**Western Sydney Stadium Stage 2 Design & Construction - Modification 3 (SSD-8175  
Mod-3)  
Response to Submissions**

## ATTACHMENT 1: Key Issues

**Figure 3 – SoundPLAN Western Sydney Stadium Noise Model**

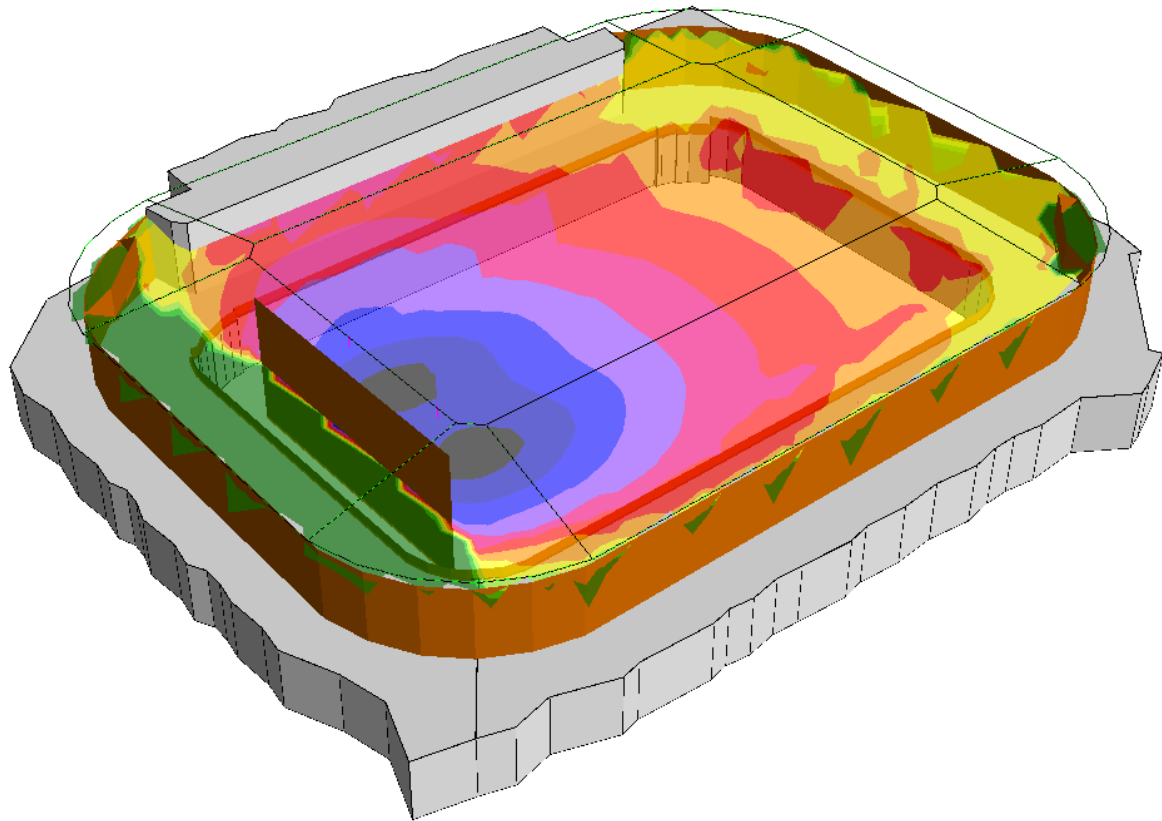
- Further consideration and justification in relation to the number of concerts requested noting that it is stated most artists perform two concerts and the number of concerts requested is five.
- The Department considers that it is insufficient to base the conclusions on the noise generated by concerts upon modelling only. As additional concerts are being requested, and no concert has been held at the Western Sydney Stadium to date, additional detail on the noise monitoring and management procedures that will be implemented for concerts is requested. This should include consideration of an alternative and contemporary method of assessment and management of noise from concerts.
- Specific detail on how the Operational Management Plan and Operational Noise Management Plan will be updated to address any potential temporary or permanent increase in major sporting events or concerts.
